CITY OF ALBUQUERQUE

**Re: Central and Unser Development
Traffic Impact Study (K10D063)**
DRAFT dated June 25, 2024
Via email jroberts@tierrawestllc.com

The subject Traffic Impact Study (Study) draft received on July 12, 2024, has been reviewed by the City of Albuquerque Planning Development Transportation Section. The City has the following comments to be addressed.

ENGINEER'S SEAL	7707 W CENTRAL ALBUQUERQUE, NM	DRAWN BY LN
	CONCEPTUAL SITE PLAN	DATE 12-09-21
		DRAWING 2021007_SPE
RONALD R. BOHANNAN P.E. #7868	TERRA WEST, LLC 5571 MIDWAY PARK PL NE ALBUQUERQUE, NEW MEXICO 87109 (505) 858-3100 www.tierrawestllc.com	SHEET # C1
		JOB # 2021007

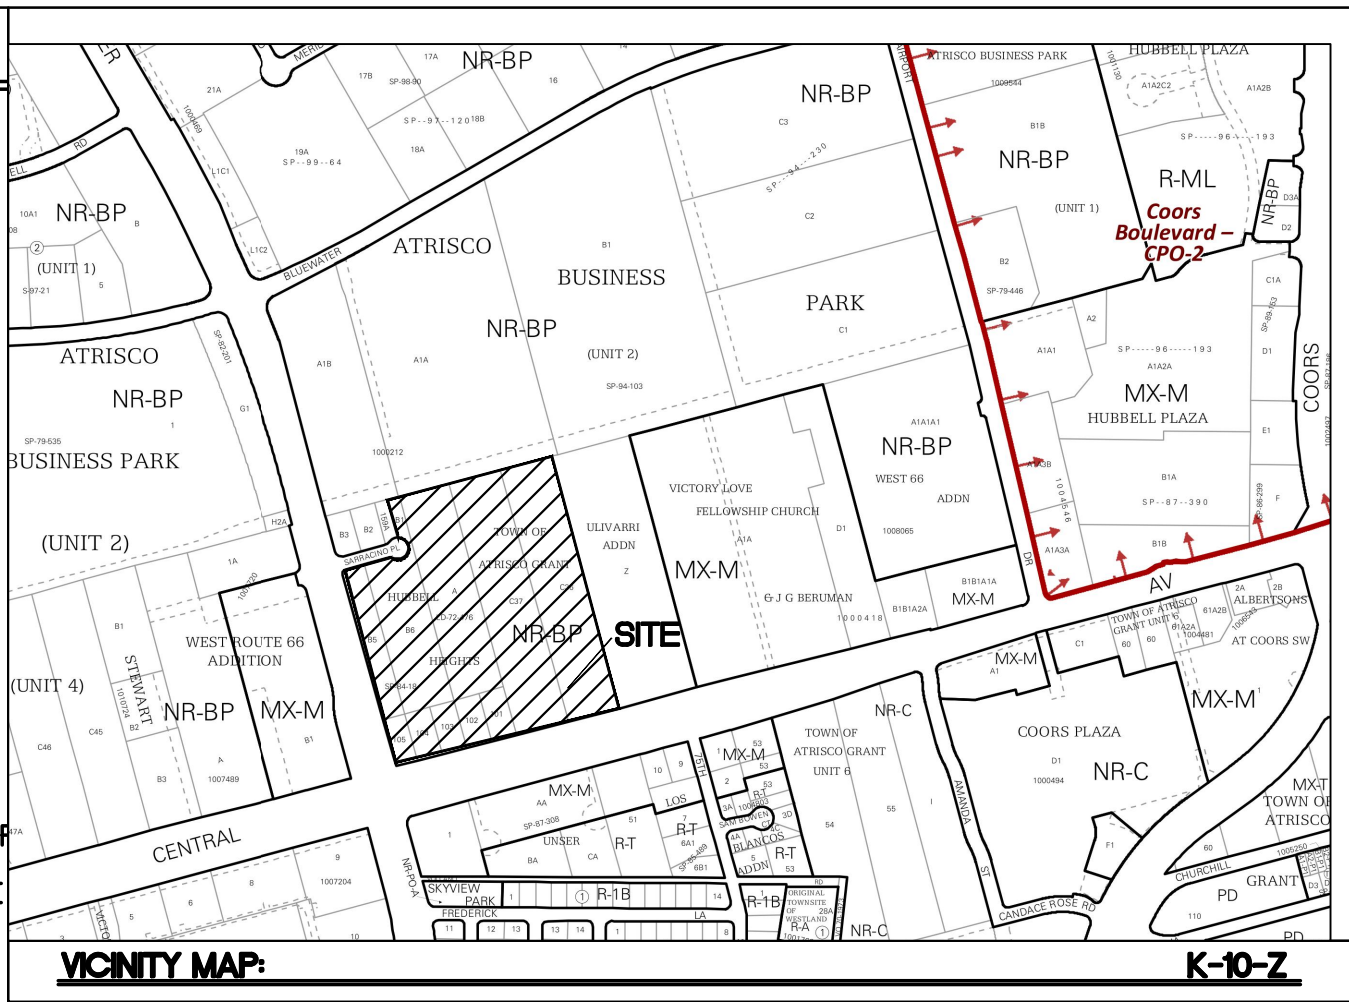
Response: All accesses other than Sarracino Place have been eliminated from the design as requested.
4. There are too many driveways/conflict points proposed on Central Ave. It is preferable to have just one access on Central Ave as discussed in #1 above.

Response: The number accesses to the development have been reduce to 4 instead of 6:
 1. Driveway “A” - Sarracino Pl/Unser (Full Access, Existing, Signalized)

2. Driveway “B” (Formerly “E”) - Central Ave./Driveway “B”(Full Access, Proposed, Unsignalized),
 3. Driveway “C” - Central Ave./Driveway “C” (Right-in/Right-out, Proposed, Unsignalized)

4. Driveway “D” - Central Ave./Driveway “D” (Right-in/Right-out, Proposed, Unsignalized)
- *In Table 7.4.46 of the DPM, the maximum allowable number of commercial access points per site off a Principal Arterial is 1-2 access points per 300-ft of road frontage. This site has 1775-ft of frontage which would allow up to 11 access points. Just along Central Ave., which has 900-ft of frontage, the standard would allow up to 6 access points.*

- *There are currently 6 commercial access points to the proposed site on Central Ave. The new development would reduce the number of access points to only 3. The remaining 3 would be decommissioned.*

- *The proposed access points would meet the minimum spacing requirements listed in Table 7.4.45 of the DPM ((300-ft Approach Distance & 200-ft Departure Distance)*
